WEST SUSSEX COUNTY COUNCIL CONSULTATION

TO:	Arun District Council FAO:Stuart Corbey
FROM:	WSCC - Highways Authority
DATE:	5 April 2019
LOCATION:	Garage Premises, Main Road, Yapton, BN18 0EA
SUBJECT:	Y/22/19/PL Demolition of existing redundant garage building & erection of 1 No. dwelling and associated works (alternative following Y/68/17/PL). This application may affect the setting of listed buildings & may affect the character & appearance of the Main Road/Church Road, Yapton Conservation Area.
RECOMMENDATION:	More Information
S106 CONTRIBUTION TOTAL:	£N/A

PROJECT	CLIENT	DATE	DRAWN
Reptune Garage site Main Road YAPTON	P Mountford	Feb 2019	pm
DRAWING	SCALE	DRAWING NO	REV
Block plans as existing and proposed	1:500@A3	1801/07

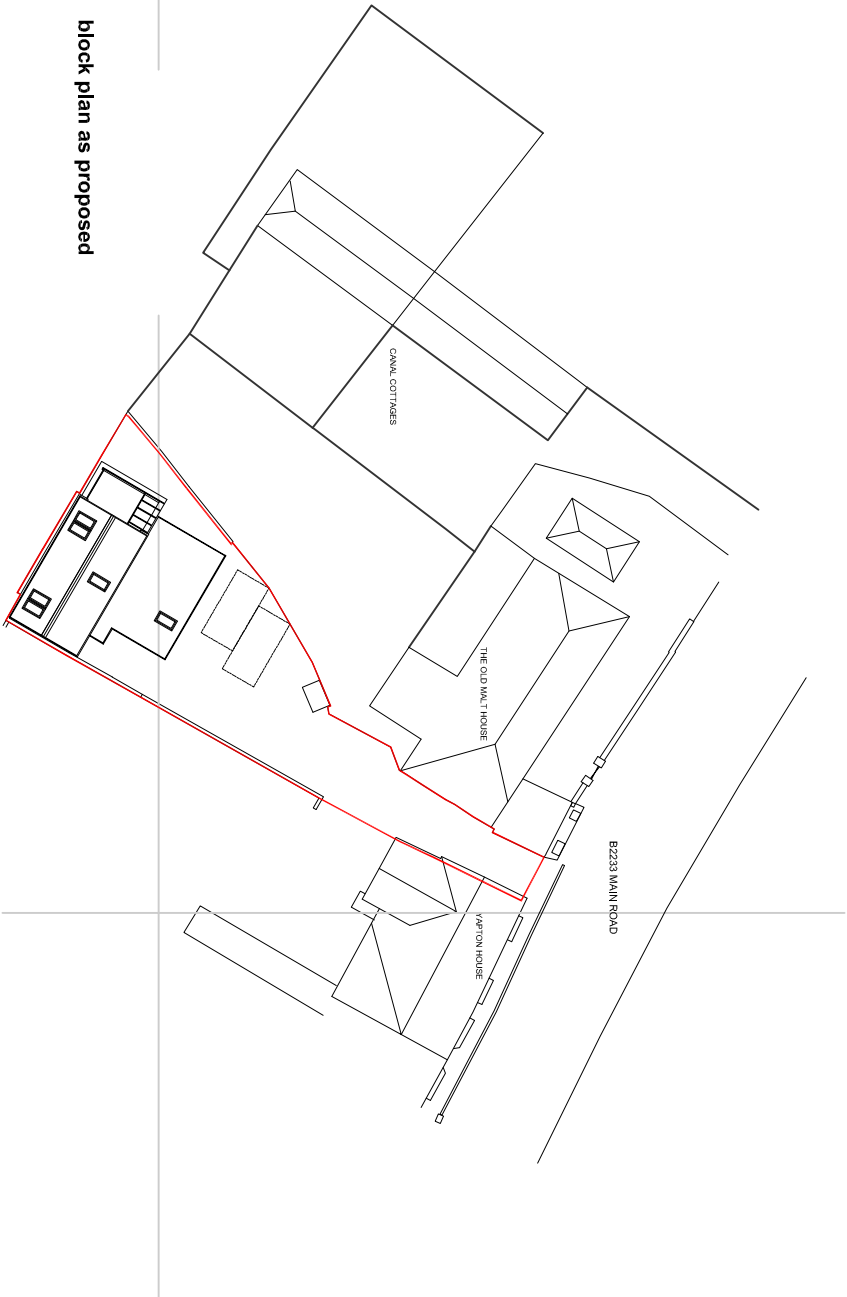
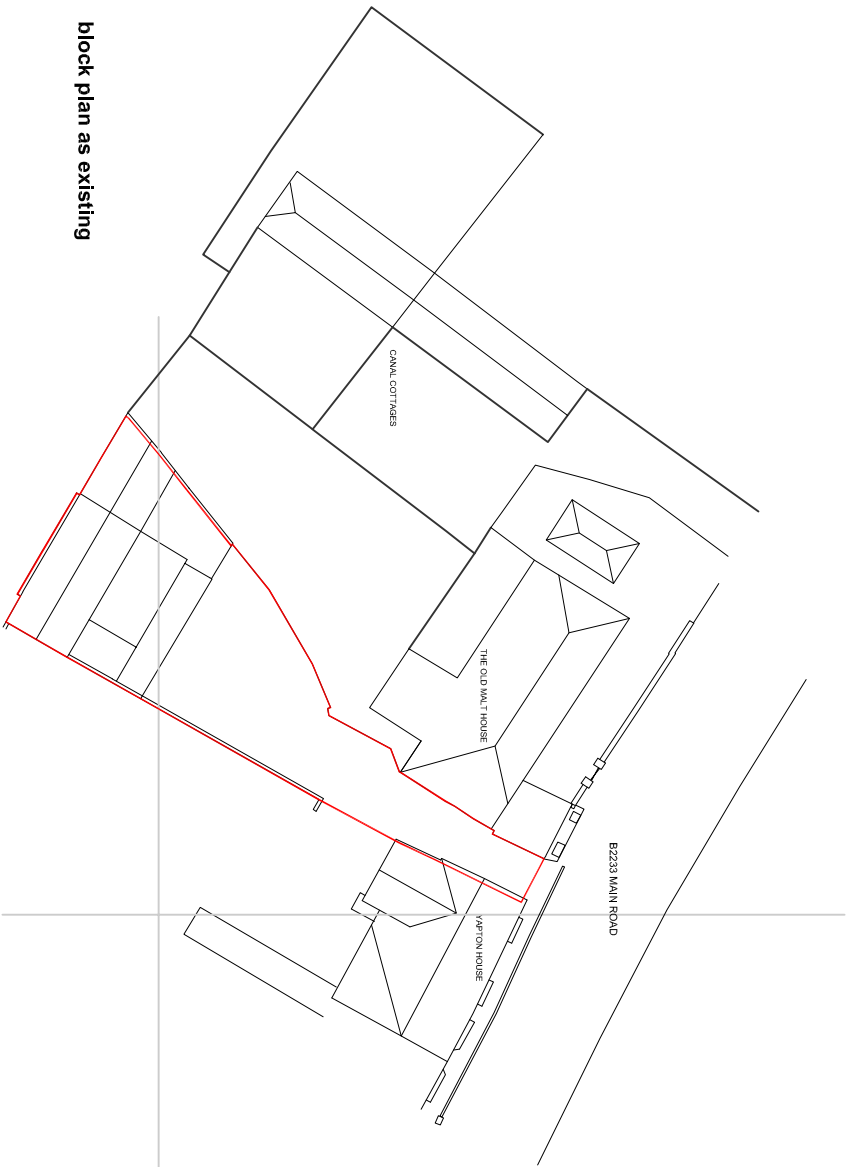
The revised parking arrangement does not appear workable. Whilst it is appreciated that the Design & Access Statement refers to these spaces as being extra-wide to allow for reduced aisle width they have been marked out at 2.4m by 4.8m and the staggered arrangement reduces the available width for turning further. Manual for Streets 2 paragraph 11.1.9 states that 6 metre clear space should be provided for such spaces. Widening and slight relocation of the spaces may improve the manoeuvre to ensure a car can easily turn on site in order to exit on to the public highway in a forward gear. The applicant is advised to demonstrate the workability of any amended parking spaces through swept path tracking.

Please ask the applicant for this additional demonstration of parking arrangements and re-consult.
